**Re: Planning Rationale Addendum Letter to Site Plan Control Application for 800 Eagleson Rd,
5264 Fernbank Rd (Application No. D07-12-18-0096)**

Ironclad Developments Inc. ('ICD') is the applicant and author of this addendum to the Planning Rationale report submitted to the City of Ottawa in support of a site plan control application for the property at the above-mentioned address ('the subject lands') that would ultimately permit a six storey, 143-unit apartment building. As part of the application package, ICD prepared a planning rationale that was submitted on June 15, 2018; the purpose of which was to evaluate the proposed development with respect to the applicable provincial and municipal regulatory framework and determine if the proposed development is compatible on the subject lands and with the surrounding community.

This letter is an addendum to the original planning rationale. Since the site plan control application has not been deemed complete by City of Ottawa planning staff, this letter is to be read in conjunction with the original planning rationale to provide context regarding the updated site plan (Appendix A) to the applicable planning policy framework as desc

Project Number	1802	
Date	OCT 31, 2018	Rev Date
Drawn By	TT	
Checked By	RG	
Sheet No.	A001	
Scale	AS NOTED

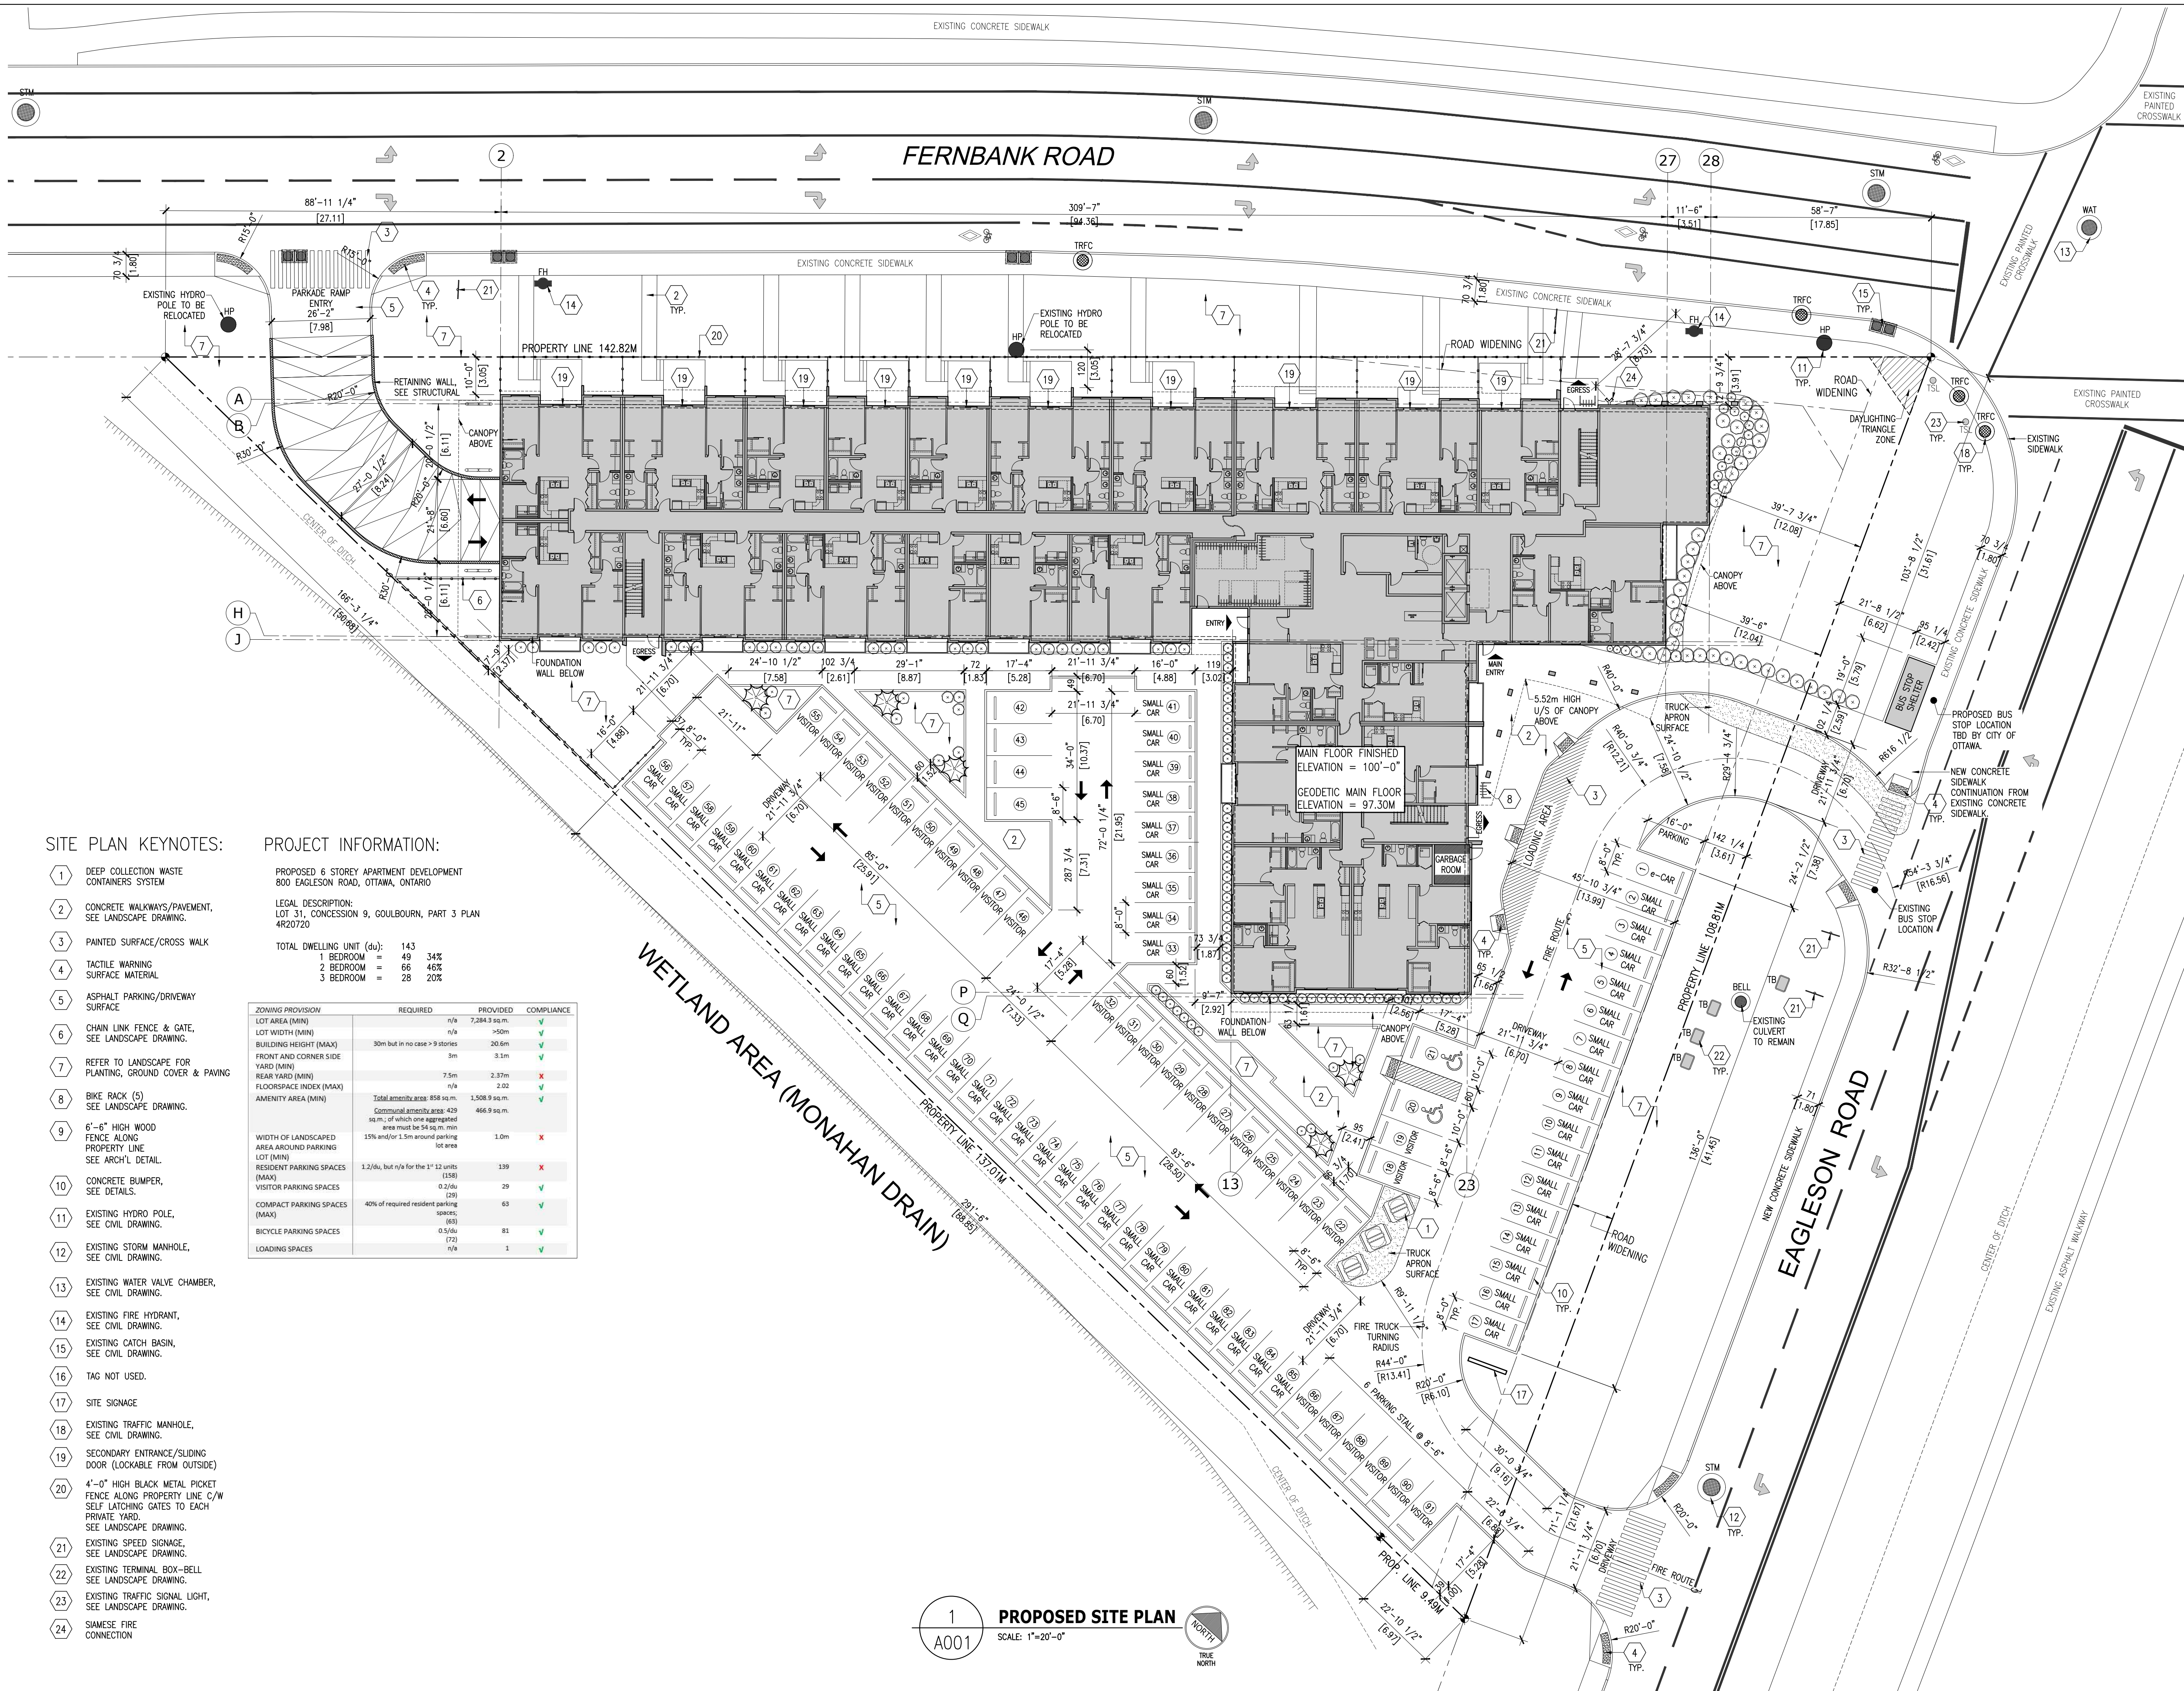
Since the original application was submitted, a revision to the site plan has been made with respect to the parking layout and the amenity space in the rear yard. These revisions were made in response to comments made by members of the Urban Design Review Panel ('the panel') at ICD's hearing at the panel on July 5, 2018. Among the panel's concerns were the following:

- Incompatibilities with the drop-off area and the parking lot in front of the primary entrance off Eagleson Rd;
- Issues with the site's internal circulation; particularly for fire trucks and other large vehicles;
- The large amount of surface parking in the rear yard, resulting in isolated pockets of landscaping/amenity space; and
- The lack of a landscaped buffer between the building's exterior walls and the hard-surfaced parking area

The outdoor surface parking configuration has been modified to improve circulation as well as to better integrate the amenity areas with the building. The primary entrance off Eagleson Road has been moved further south in order to add a secondary 'right-out only' exit. The amount of surface parking has been reduced by eight (8) spaces, greatly simplifying the parking circulation and reducing the chance of collisions – especially collisions involving larger vehicles. Additionally, the laneway connecting the surface lot to the Fernbank Road entrance has been closed; all incoming vehicles utilizing this entrance is directed to the underground parking garage.

The reduction to the surface parking area facilitates an increase in the amounts of landscaped greenspace. The buffer between the building's exterior and the parking has been increased to three metres. An interconnected pedestrian pathway now connects the main entrance to the refuse containers and the proposed multi-use pathway atop the landscaped berm. In addition, the new surface parking layout results in new landscaped 'islands' which not only adds shared outdoor amenity space, but also helps break up the size of the surface parking lots and aids in orientation.

As mentioned previously, the total number of parking spaces has been reduced from the original submission from 172 to 164, resulting in a parking ratio of 1.15 spaces per unit. It is important to note that the required parking rate for disabled spaces remain unchanged. As such, ICD intends to seek approval from the City of Ottawa Committee of Adjustment to approve three

Project Number	1802
Date	OCT31, 2018
Rev Date	
Drawn By	MR/TT
Checked By	RG
Sheet No.	A202
Scale	AS NOTED

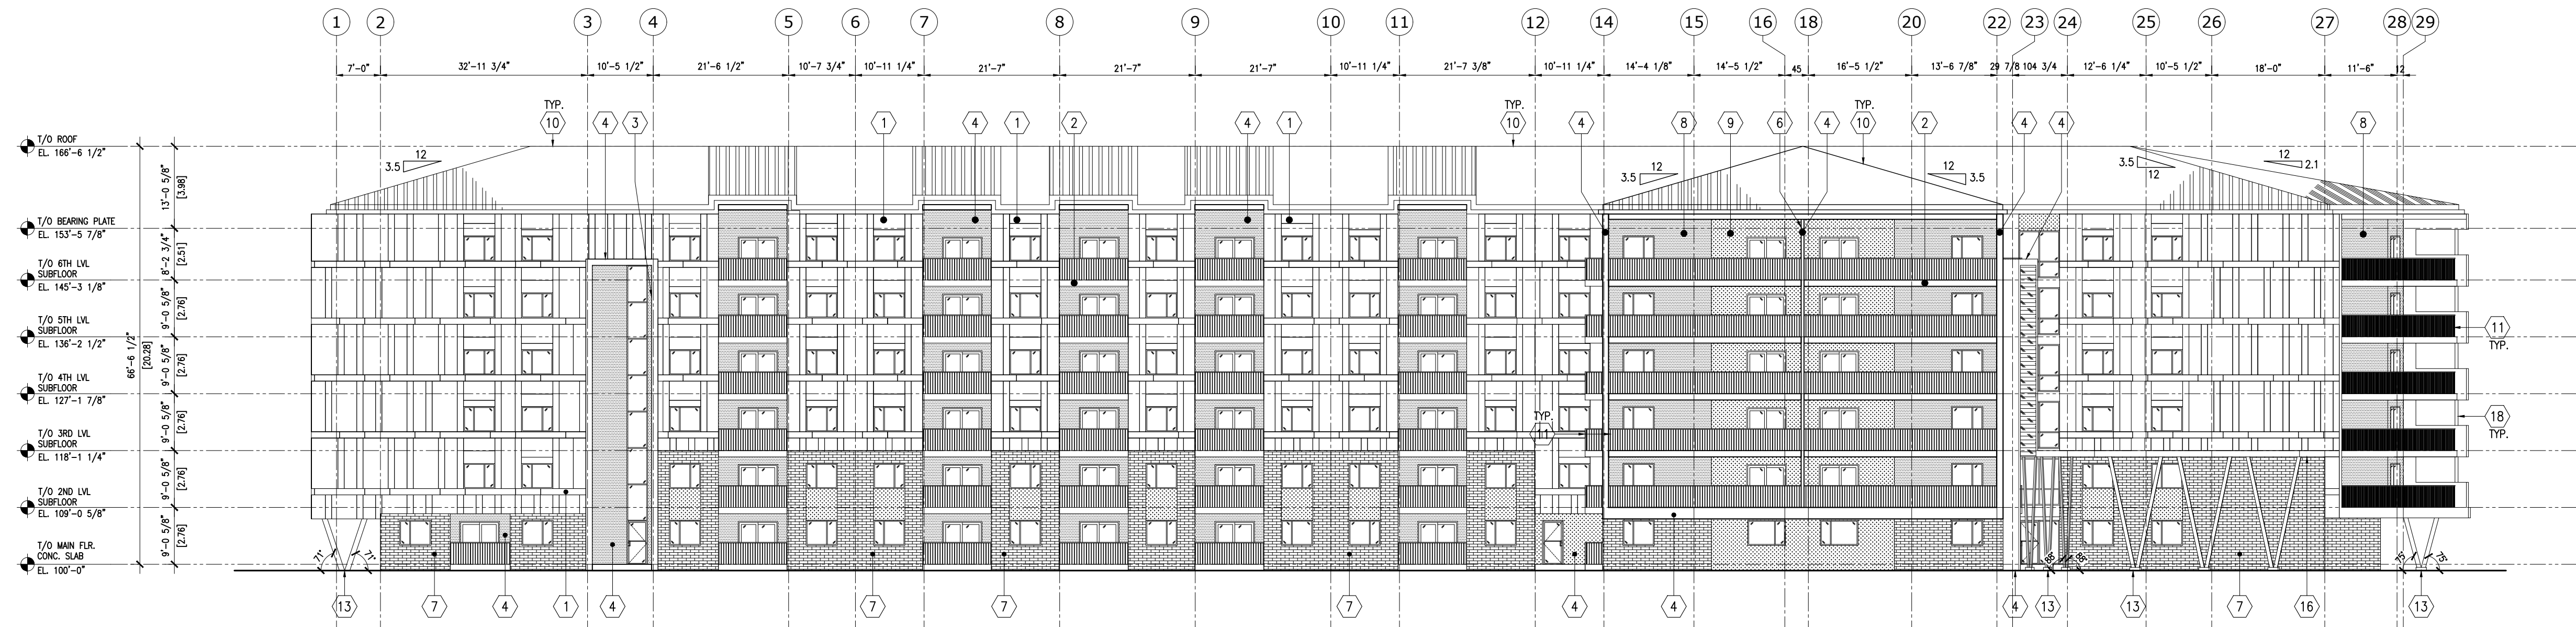
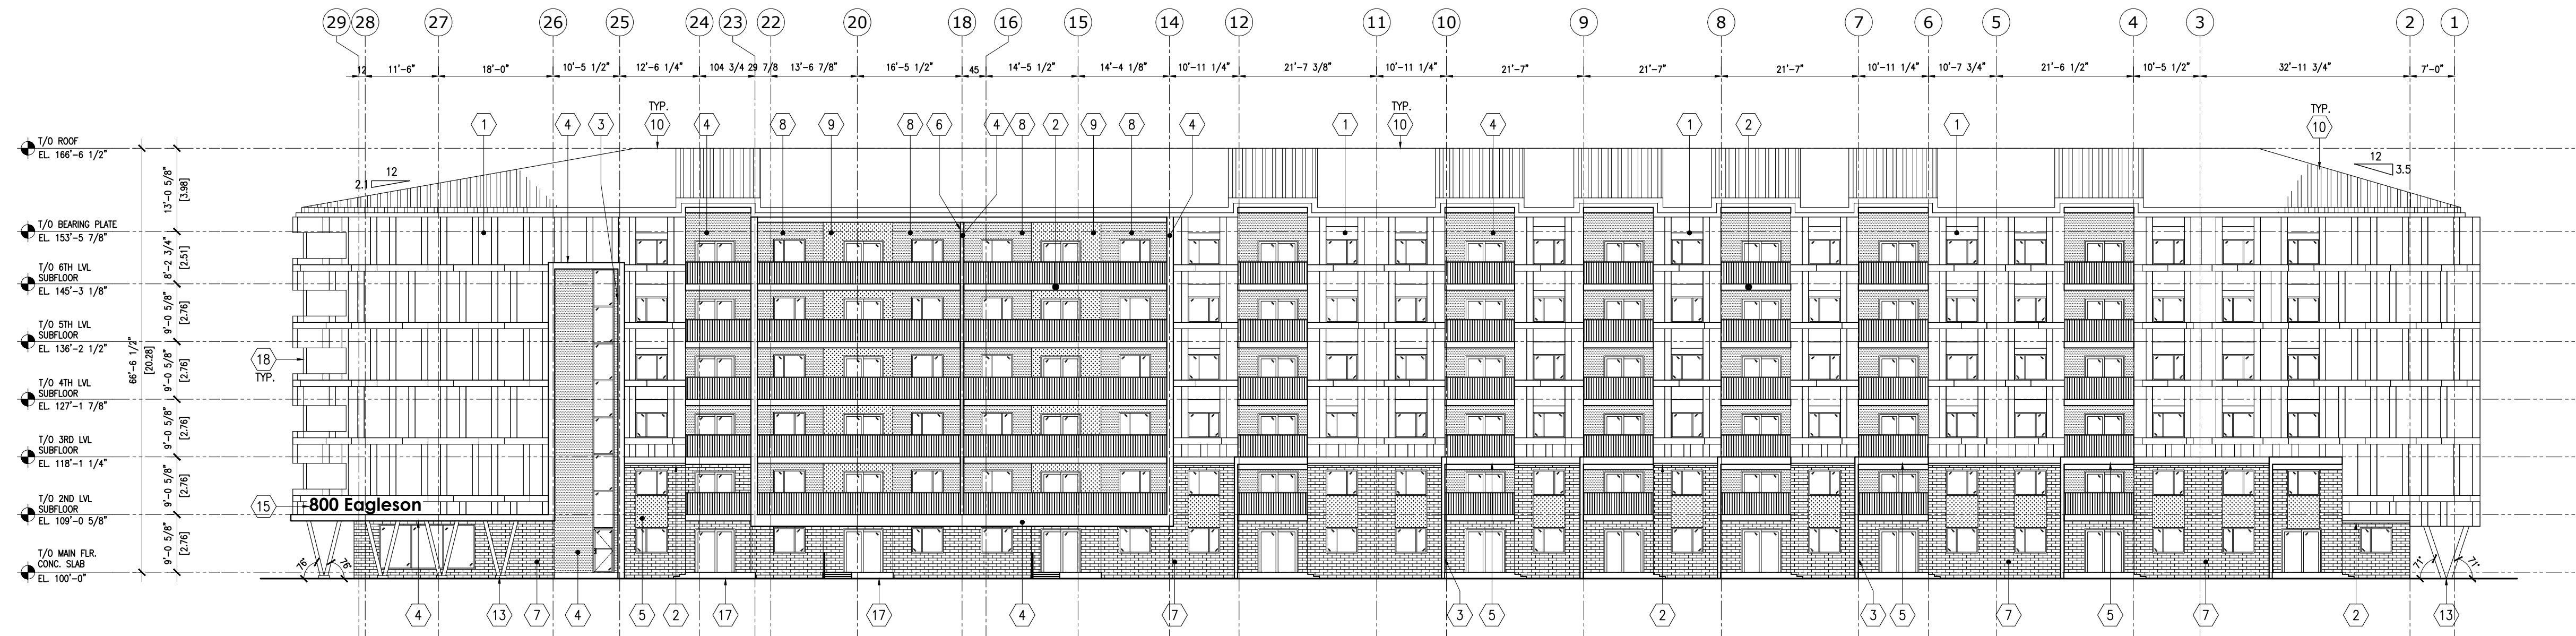
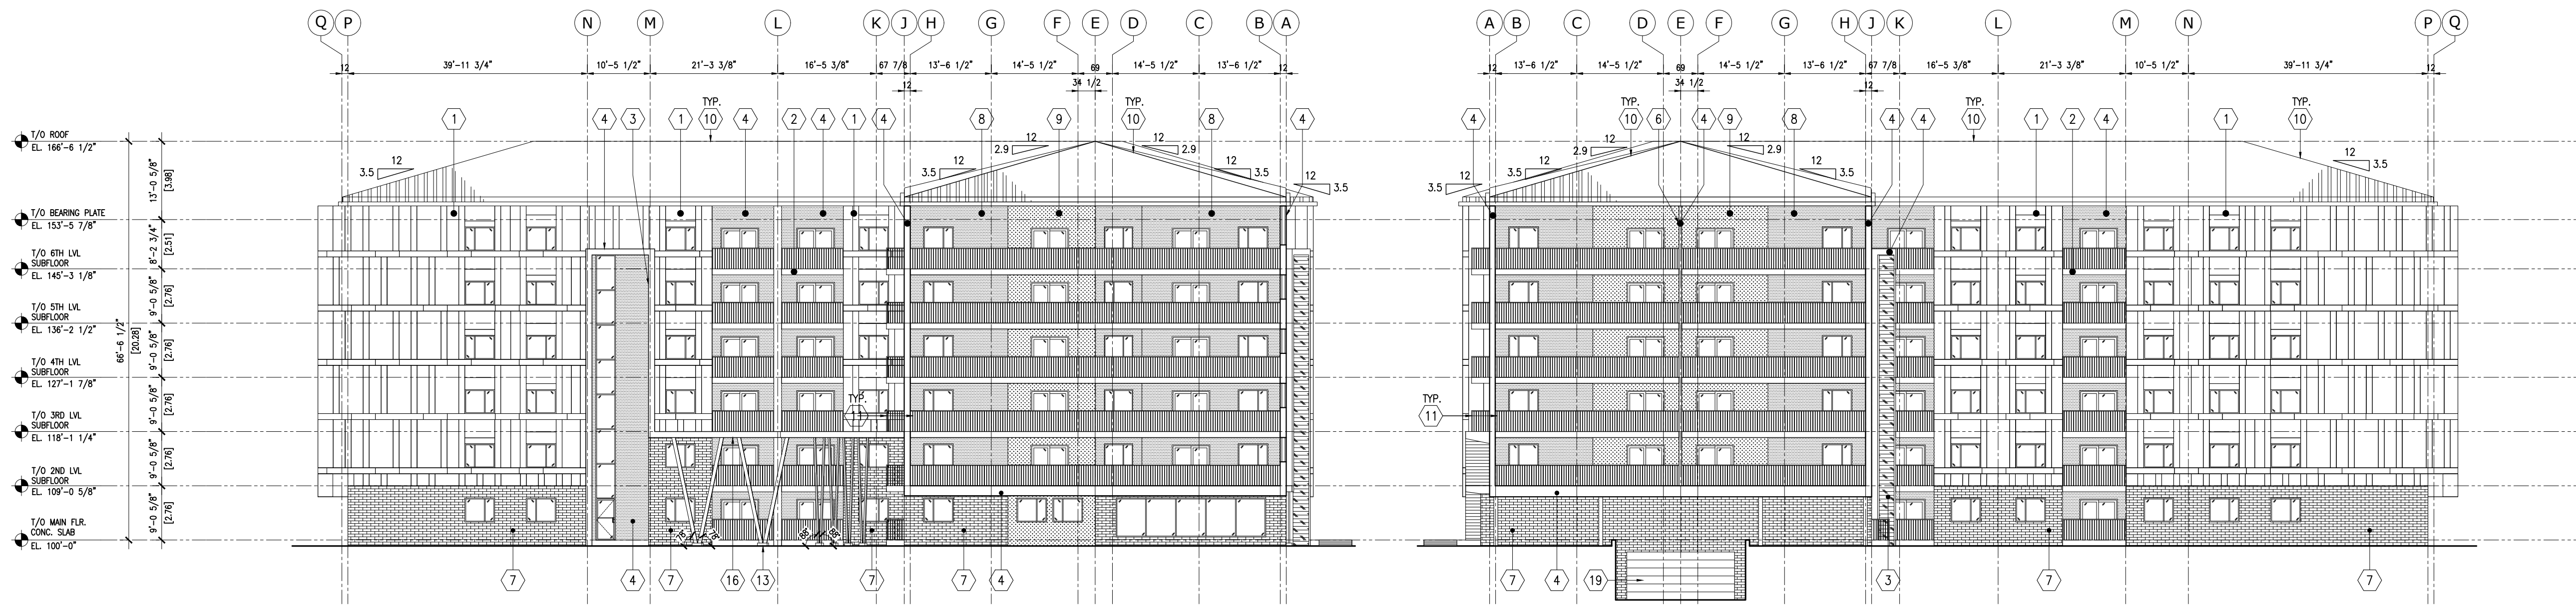
In addition to the changes to the landscaping and surface parking configuration, minor changes have been made to the exterior façade to address some comments made by the panel. As shown in Appendix B, trellises have been installed above each balcony on the 6th floor, and the applications of red paint have been significantly reduced and is now used to accent important features. The internal building plans and the underground parking plans remain unchanged from the original submission. As such, the policies from the Provincial Policy Statement, the City of Ottawa Official Plan and Zoning By-law No. 2008-250 ('the zoning by-law'), as well as the Urban Design Guidelines for Development Along Arterial Mainstreets (2006) remain in effect.
